Lead Local Flood Authority

Date 15 October 2025

RE: BE/16/25/RES – Land at Oldlands Farm, Newlands Road, Bognor Regis, PO22 9NN

Following our review of the submitted additional technical notes, the LLFA has the following comments and requests for further information:

DRAINAGE STRATEGY IMPORTANT NOTES

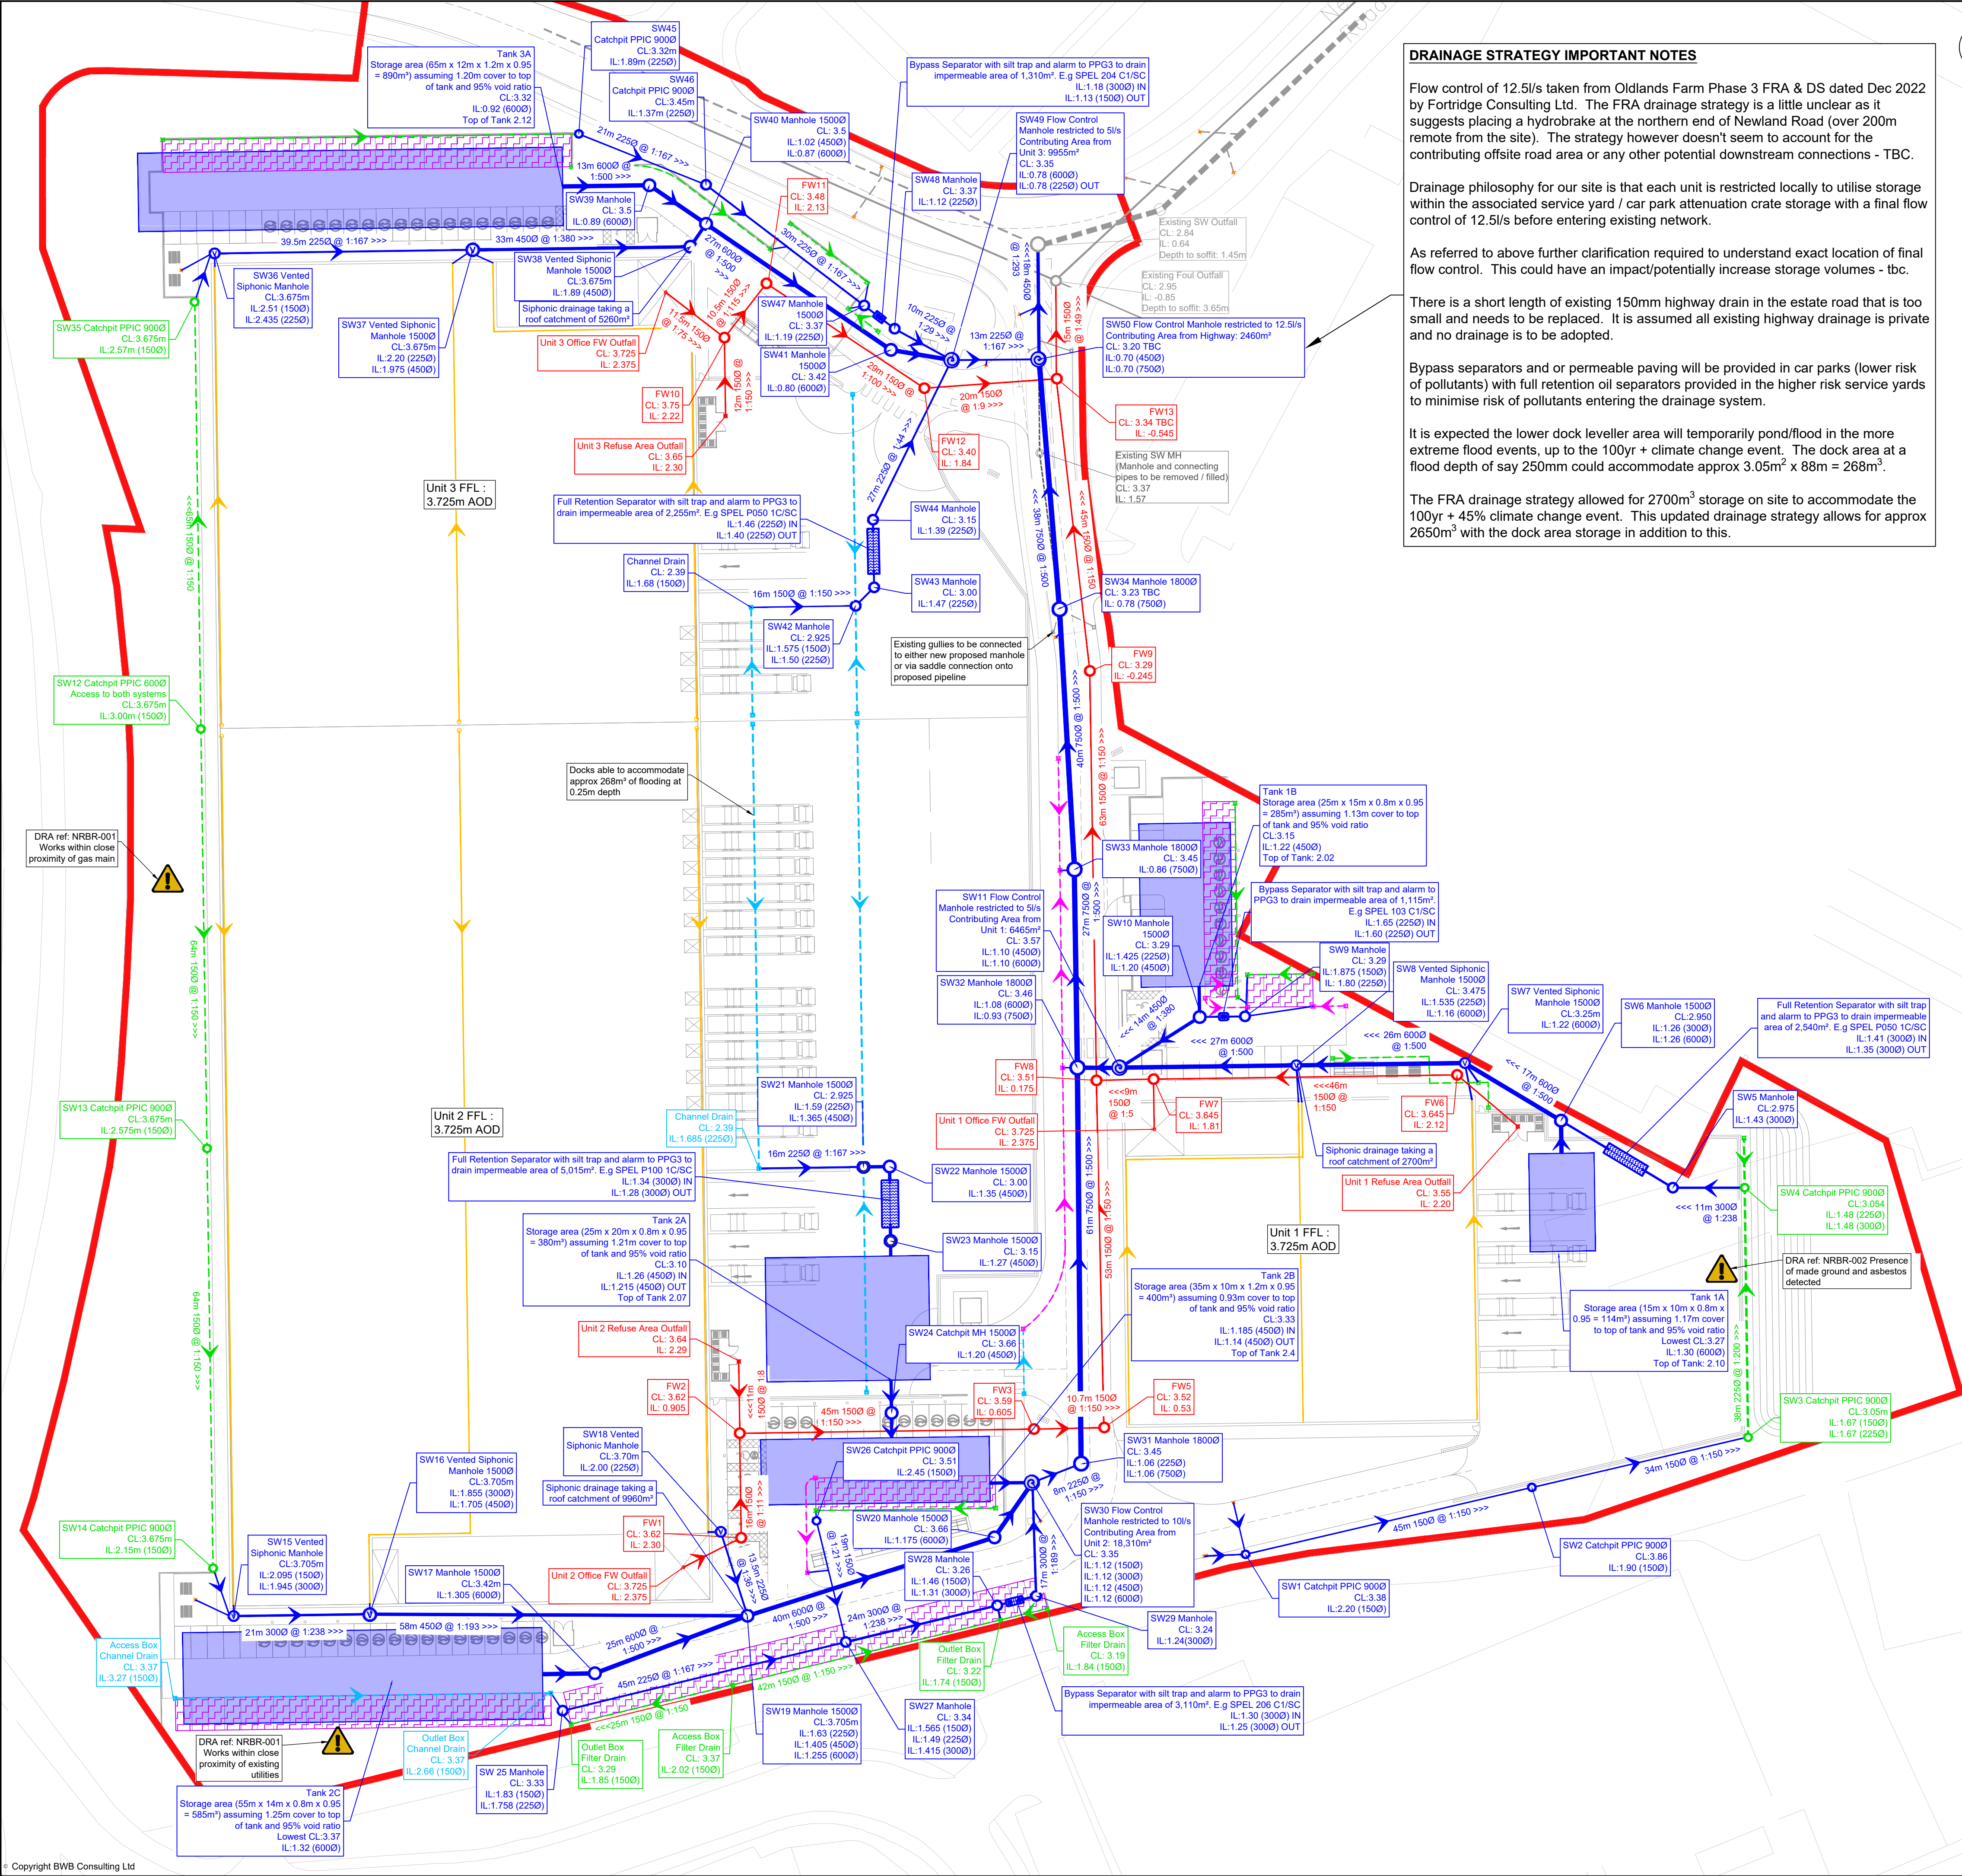
There appears to be a conflict (see image below) between the proposed crate system and the pond in the southeast corner of the site. The intended function of this pond feature is unclear. Please confirm whether this is a standalone biodiversity enhancement feature or if it forms part of the wider drainage network. Please also check other potential conflicts (e.g. in the northwest.)

We request supporting evidence to demonstrate that no conflict exists between the two features. We recommend the inclusion of a north–south cross-section through both the crate system and the pond to assist in this assessment.
